Department of Primary Industries

OUT17/29236

Inland Rail Parkes to Narromine (SSI 7475) Comment on the Environmental Impact Statement

Inland Rail Parkes to Narromine (SSI 7475) DPI Water detailed comment on the Environmental Impact Statement

**Figure 8.2e**  
Construction work stages, work areas and compounds

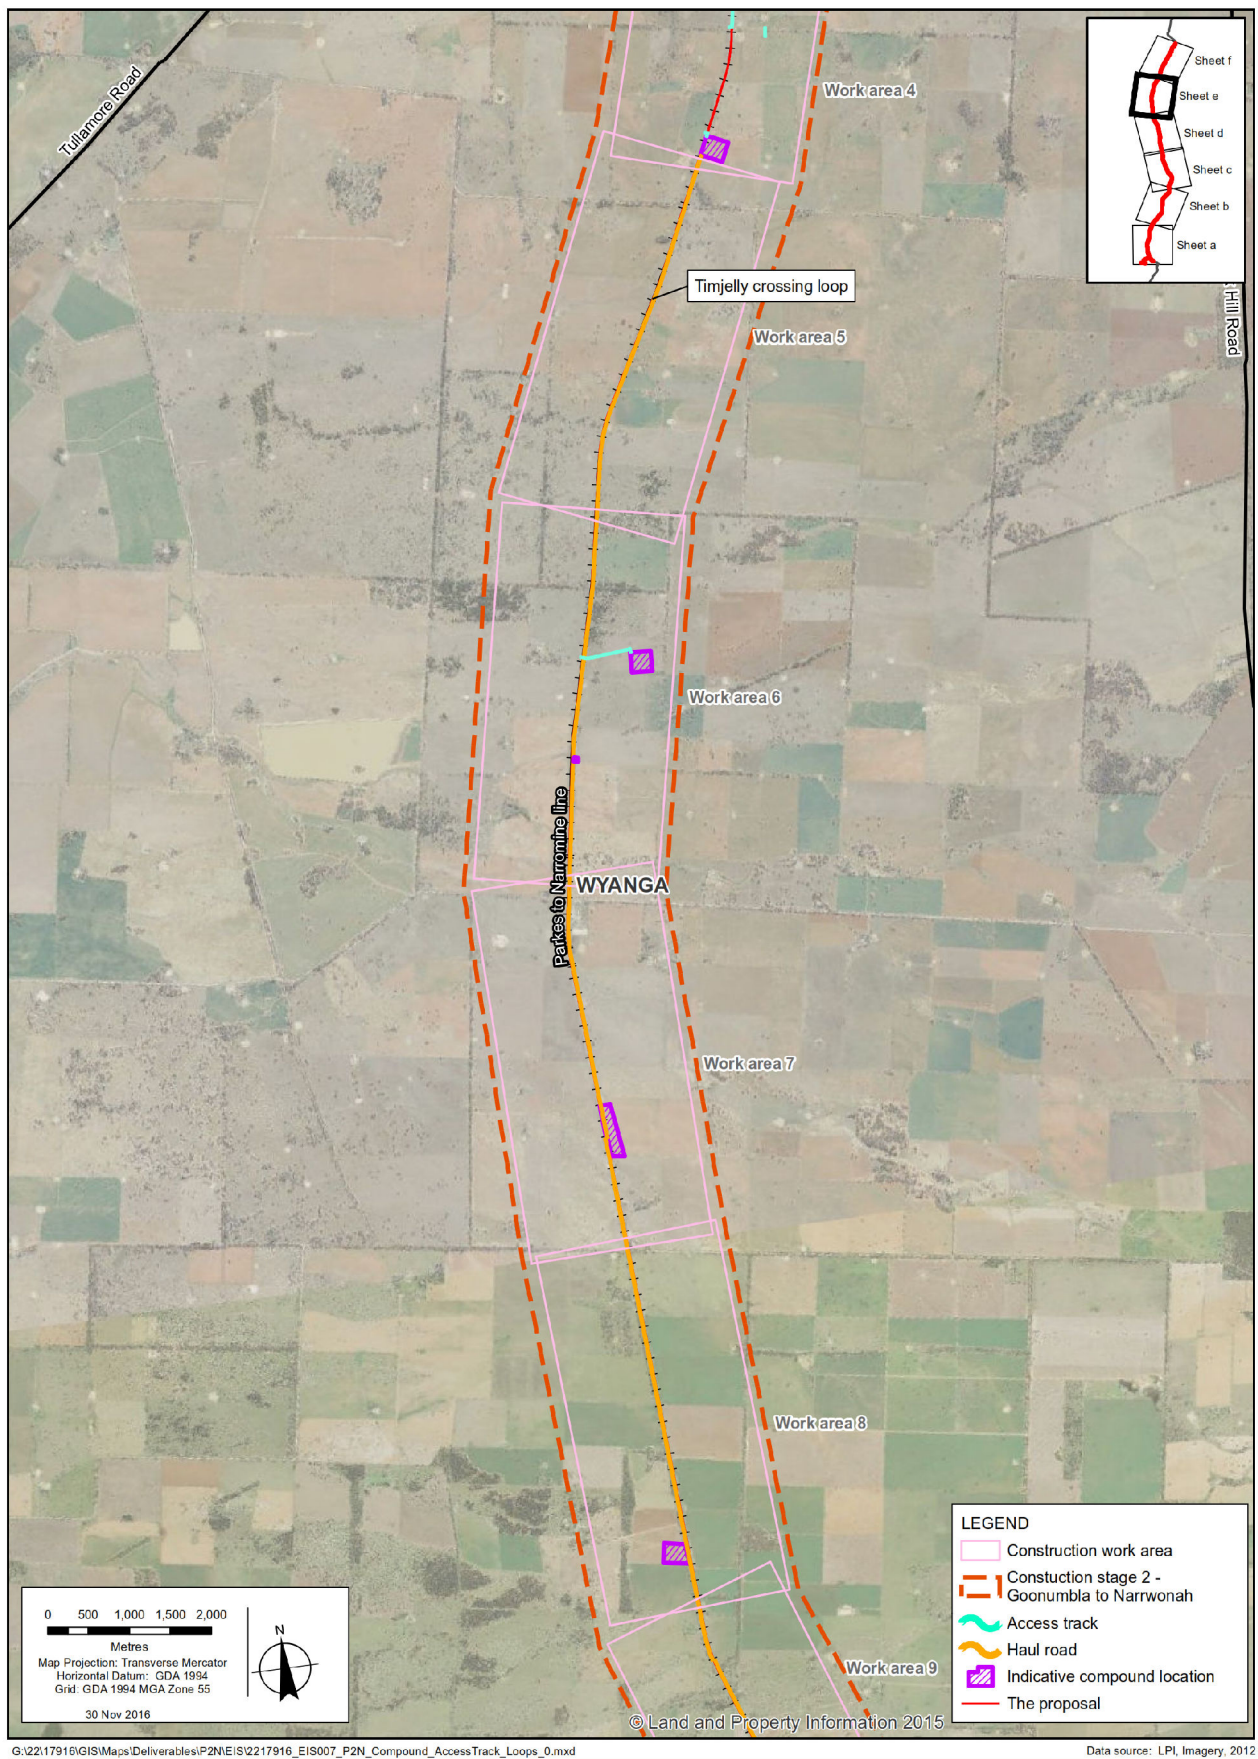
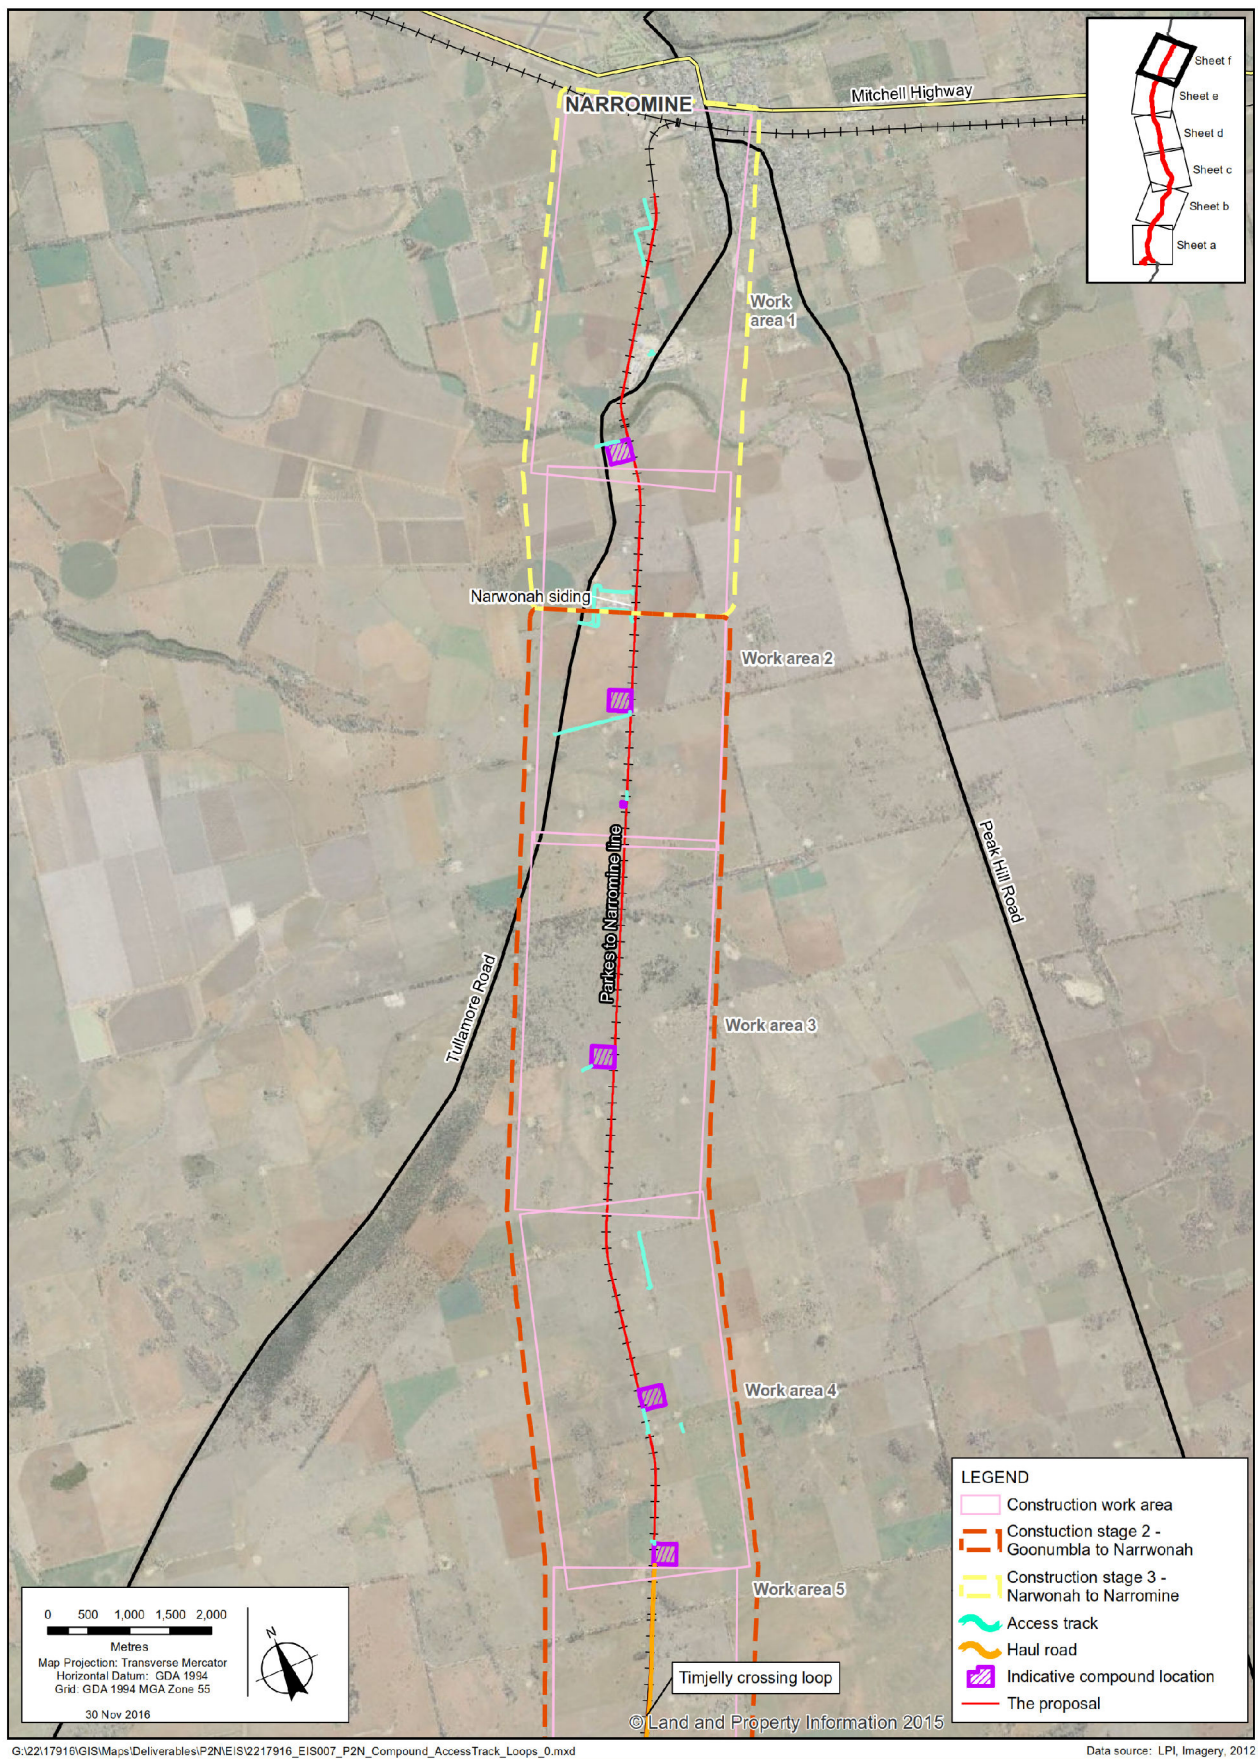
- Approximately 29 construction compounds are proposed along the rail route. Buffers from riparian vegetation have been developed based on fish habitat classifications with a 50m buffer for class 2 and 3 watercourses and 10 – 50m for other classes. DPI Water's buffers specified in the Guidelines for Controlled Activities on Waterfront Land (CAA Guidelines) are recommended as a mitigating measure to address watercourse stability and to maintain riparian vegetation.
